Our ref: DOC20/268740
Senders ref: SSD 10416

Subject: Comments from City of Parramatta Council in response to the BDAR Waiver for the Powerhouse Parramatta (SSD 10416)

IMAGE 1. Showing Tree 2 (r) and Tree 3 (l)  
IMAGE 2. Showing Trees 5-14  
IMAGE 3. Showing Tree 40  
IMAGE 4. Showing Trees 25-35 & Tree Group 58  
IMAGE 5. Showing Tree 41-46  
IMAGE 6. Showing Trees 49-52  
IMAGE 7. Showing Trees 53-55

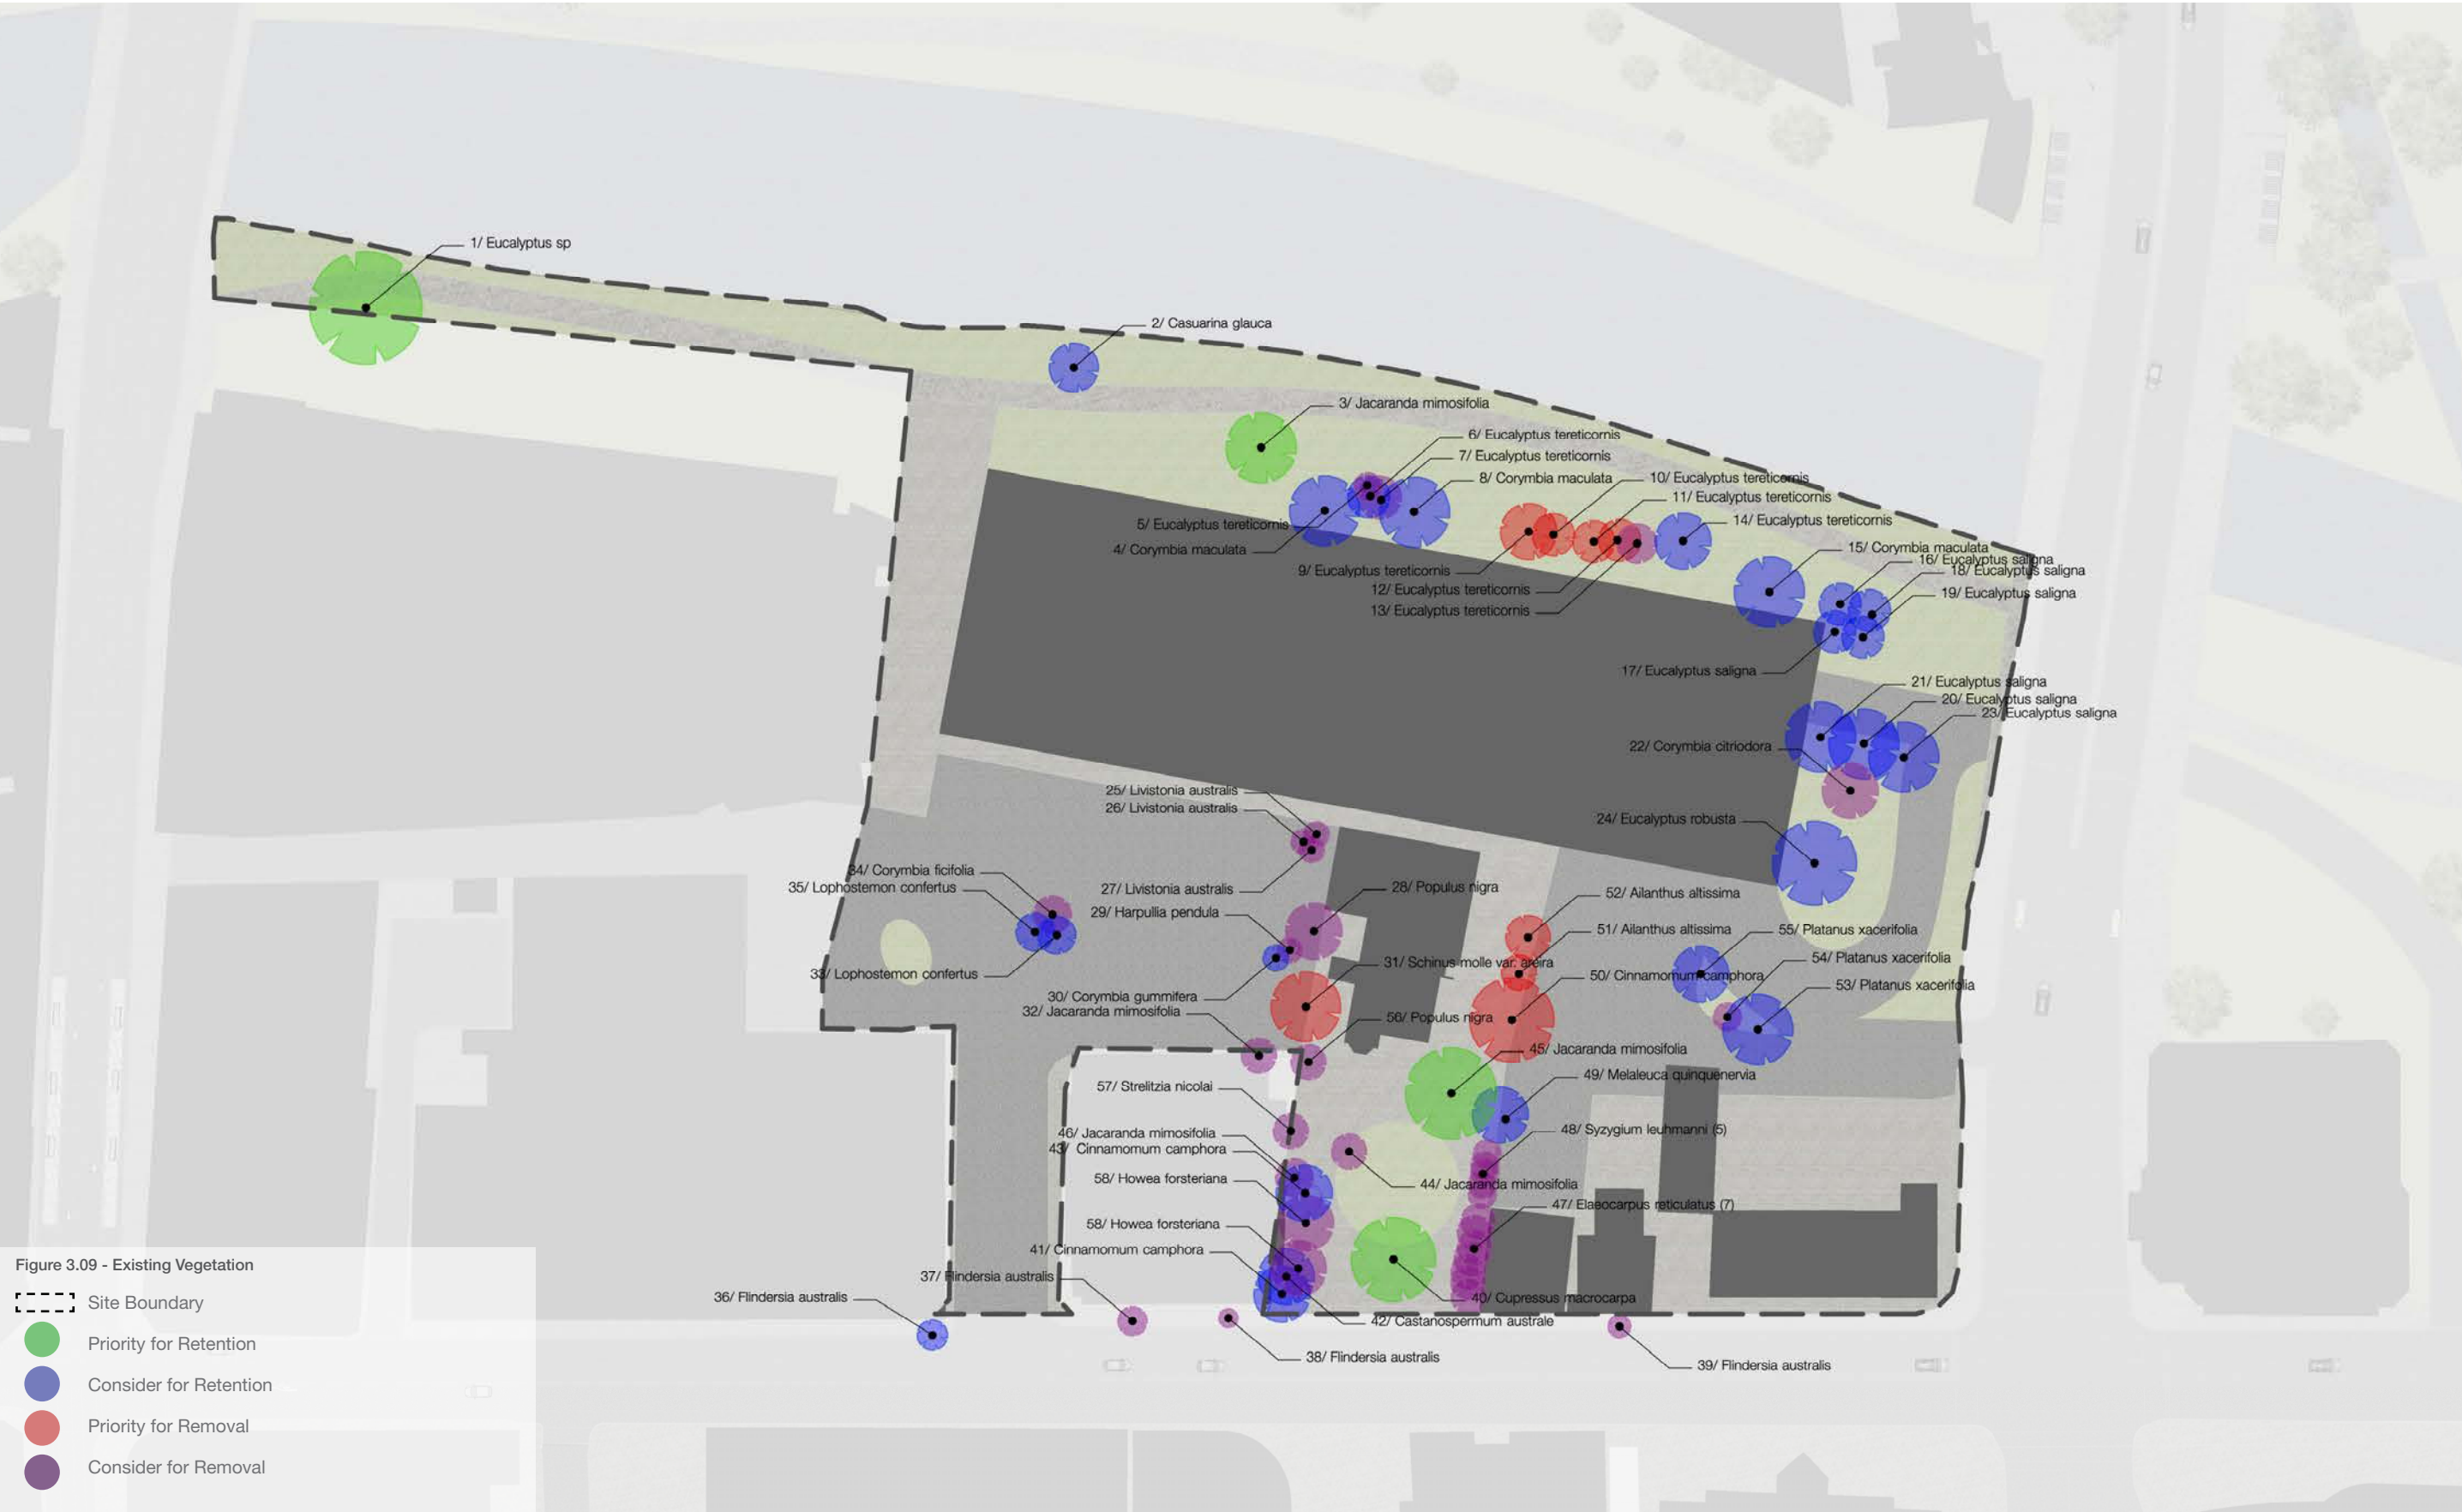
<p>The BDAR waiver identifies the presence of two likely remnant trees (Trees 1 and 2) that are not impacted by the proposed built form and are recommended for retention. However, with the exception of Tree 1, the development proposes the removal of all other existing trees along the river foreshore. These trees provide both ecological and environmental benefits, particularly shade and mitigation of the urban heat island effect, and their wholesale removal is not adequately justified. The design of the built form and public domain needs to maximise the retention of existing mature trees along the river foreshore, particularly the likely remnant (Tree 2) and those with high retention values.</p>	<p>EES supports the retention of trees where possible, and as stated above, if the number of trees to be removed has been amended then a new BDAR Waiver should be submitted.</p> <p>EES did not undertake an assessment of the contribution of the remnant and planted trees to the amenity of the foreshore and urban cooling.</p>
